PROJECT NAME: Overlook at Oxbow

PROJECT # 2018-001402

Re: Response to EPC Conditions of Approval for Project #2018-001402; Site Plan EPC SI-2018-00171

CLUSTER SETBACK EXHIBIT
N.T.S.

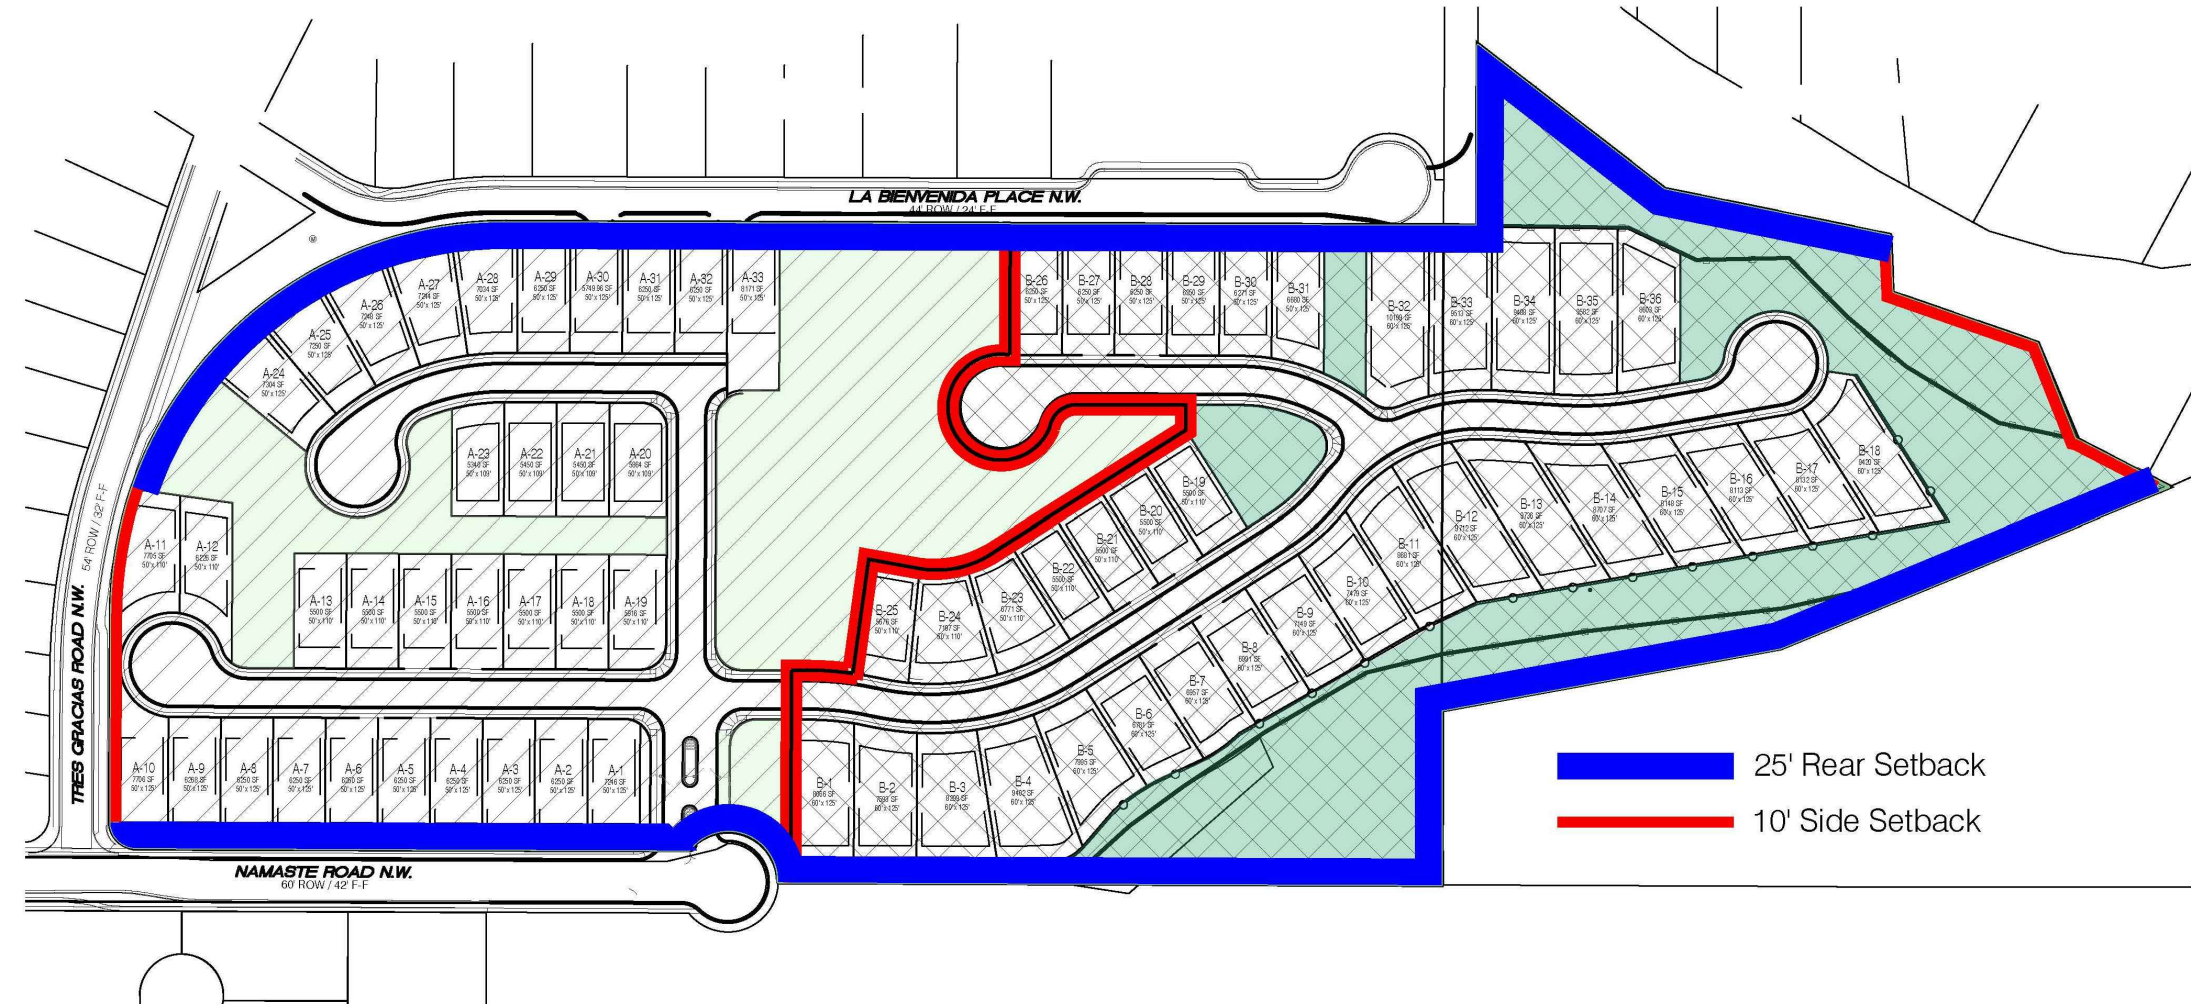
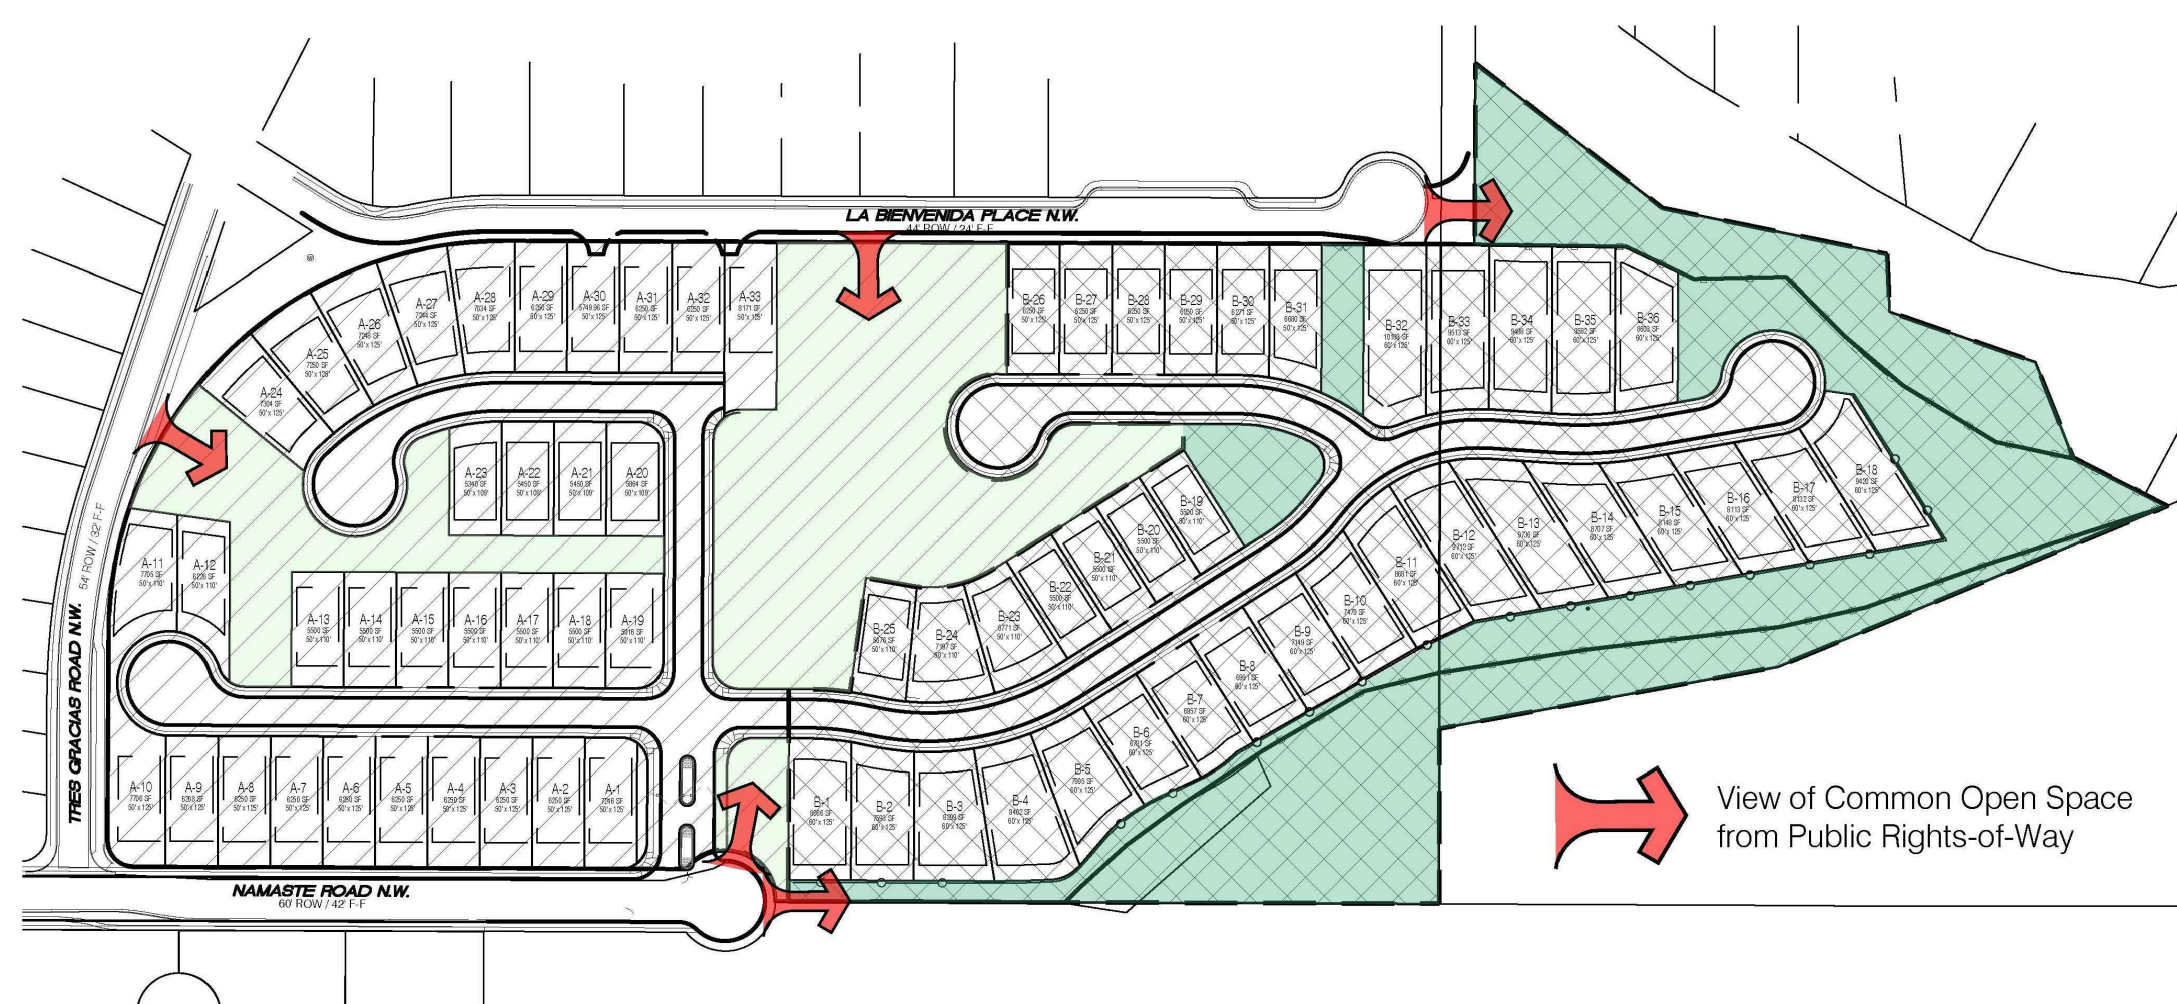
- B. The Cluster Setback Exhibit shall be included as a sheet (or part of a sheet) in the Site Plan and shall be scaled so that measurements are easy to verify.

- C. The Cluster Setback Exhibit shall indicate the location of any walls for purposes of setback measurement and shall indicate a rear setback from the homes near the middle of the subject site.

Applicant Response: A new detail sheet has been added that includes the Cluster Setback Exhibit. This combined with the larger scale drawings demonstrate compliance with the setback requirements for each cluster.

Applicant Response: The detail sheet and site plan provide information concerning the existing perimeter wall, which will be maintained. Any new or replacement wall portions shall match the existing wall color and design. Setback dimensions have been added for the lots near the middle section of the site plan (at the boundary between Cluster A and Cluster B).

LANDSCAPE PLAN

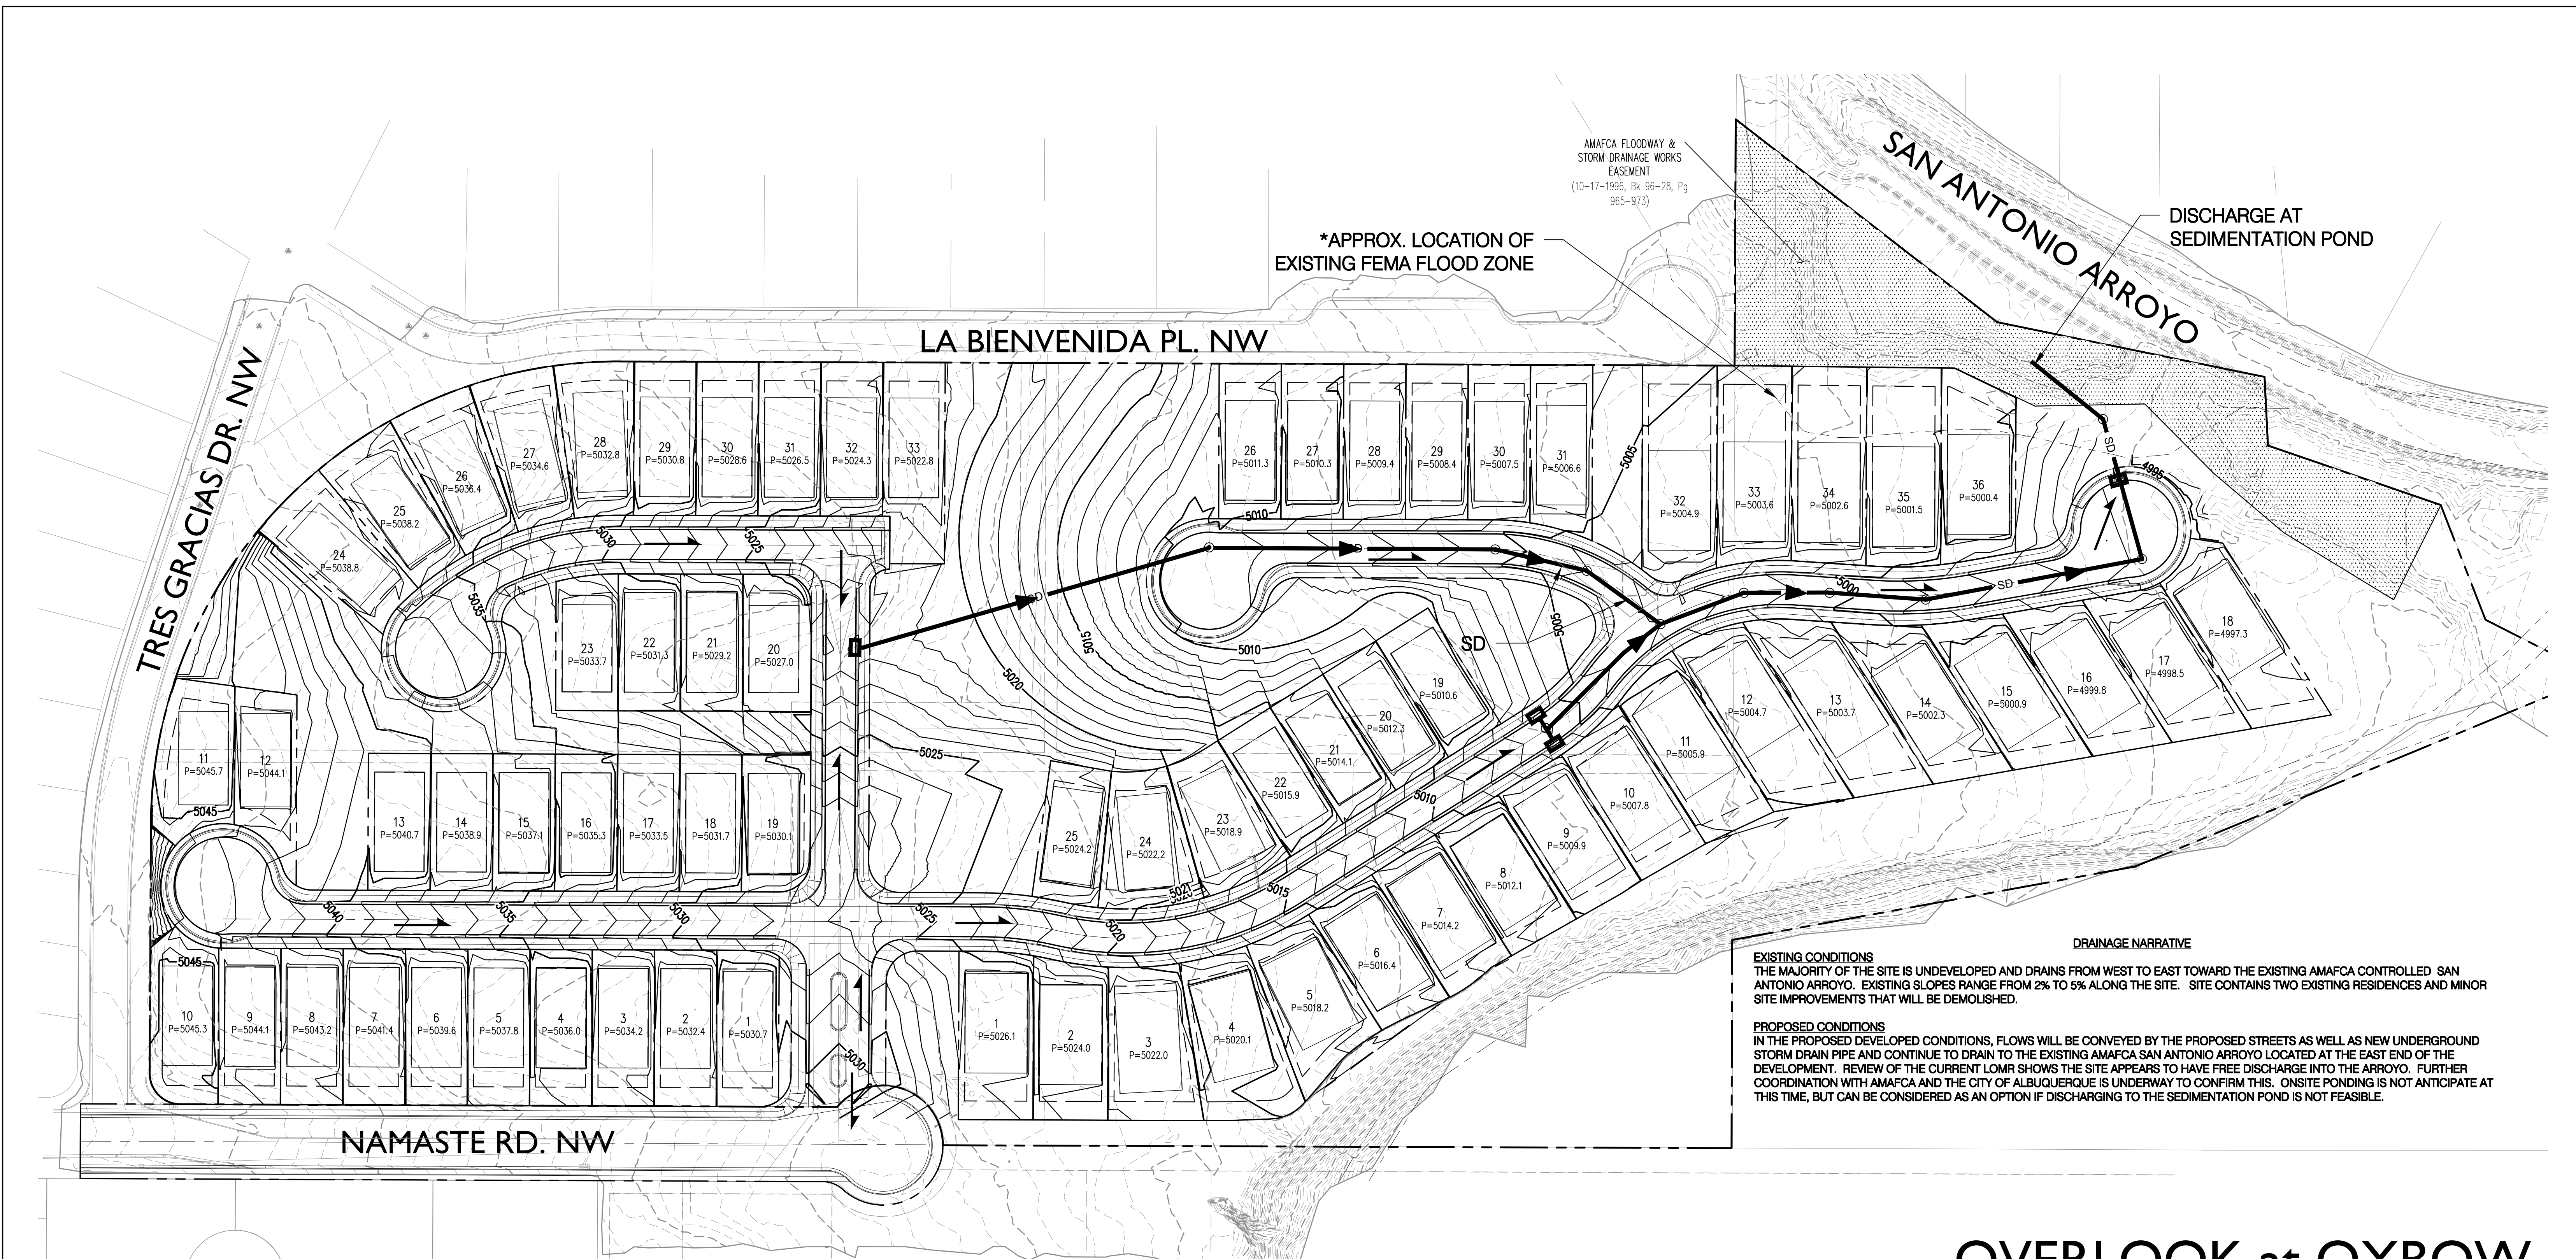
Pursuant to IDO Section 14-16-5-2(C)(I)(i)), the Pinon stand in the area shown as common open space shall be preserved. If the mature pinon pine trees cannot be retained, then they will be replaced in the same general area with new trees at a ratio of three new trees for every mature tree lost.

- A. The following notes shall be added to Sheet 1 and under Maintenance on Sheet 2:
 - i. Pursuant to IDO 14-16-4-3(B)(2)(e), the common open space for each cluster shall be on a separate subdivided lot or easement.
 - ii. Pursuant to 14-16-4-3(B)(2)(f): Maintenance for common open space areas is the responsibility of the HOA for each cluster.

Applicant Response: A note has been added to the Landscape Plan stating this requirement. The final determination will be made with the final grading plan at the time of platting.

Applicant Response: These notes have been added to Sheet 1 and the Landscape Plan (Sheet 5 – formerly Sheet 2).

CONCEPTUAL GRADING AND DRAINAGE PLAN

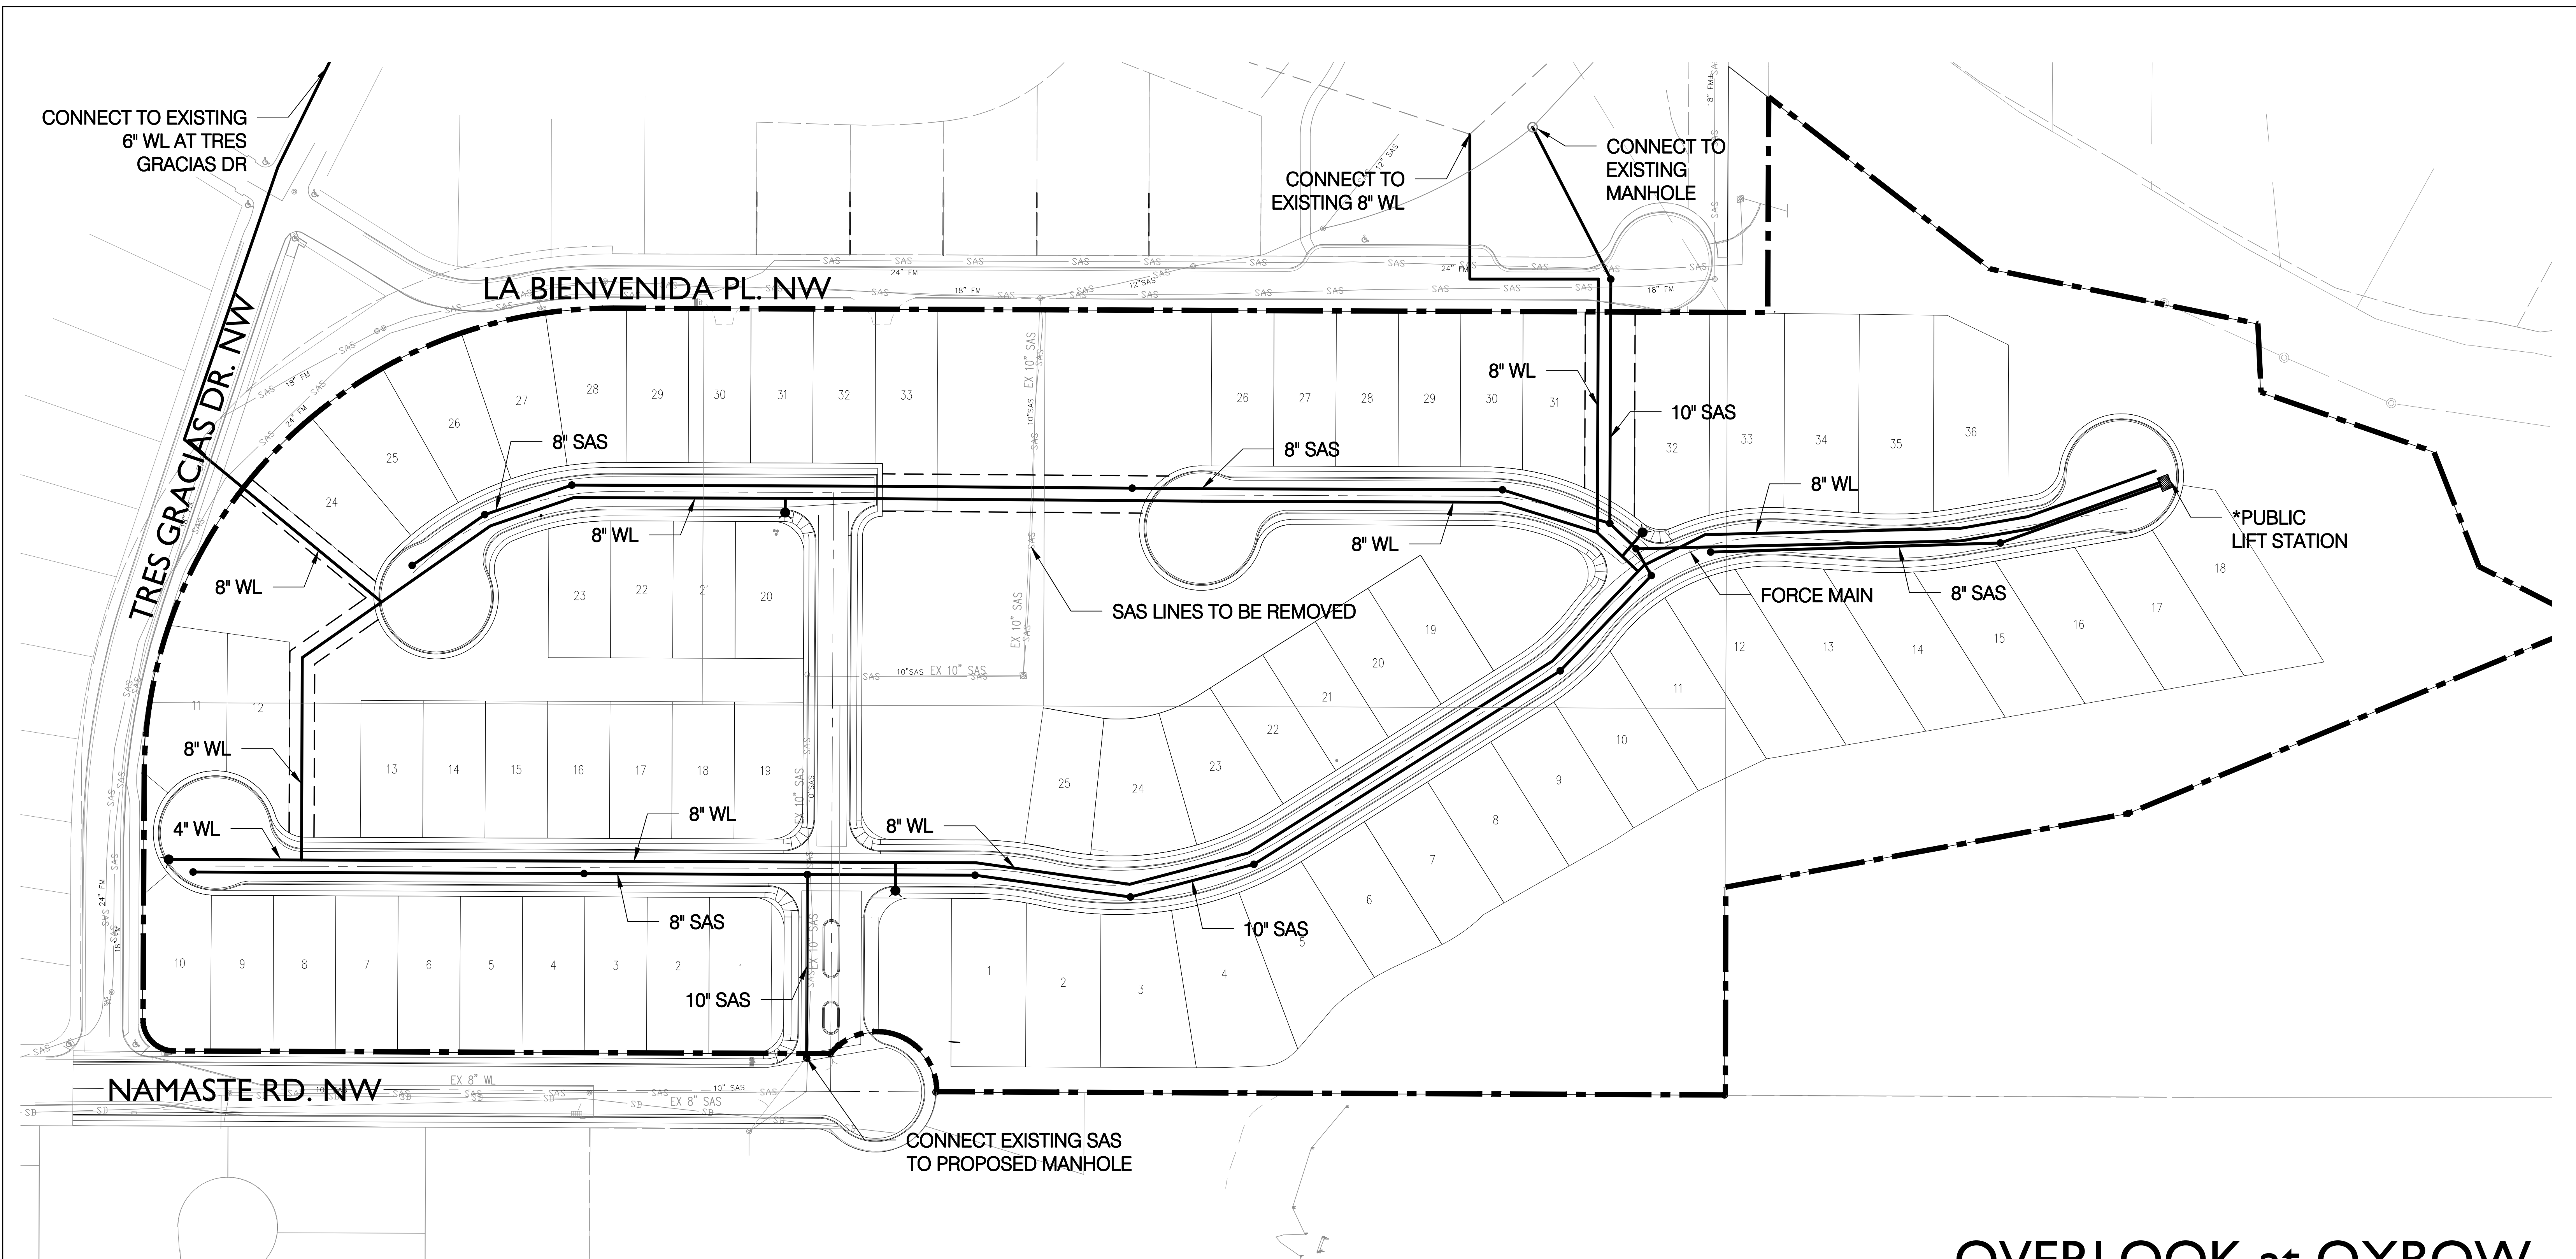
- ii. All floodplains need to be shown on the plat and site plan.

- iii. A LOMR will be required to remove the floodplain from the lots that have the floodplain.

Applicant Response: The floodplain is show on the Site Plan with a note regarding the anticipated LOMR. The LOMR Note as well as the floodplain are included on the Grading and Drainage Plan as well.

Applicant Response: Agreed, this requirement is noted on the Site Plan and the Grading and Drainage Plan.
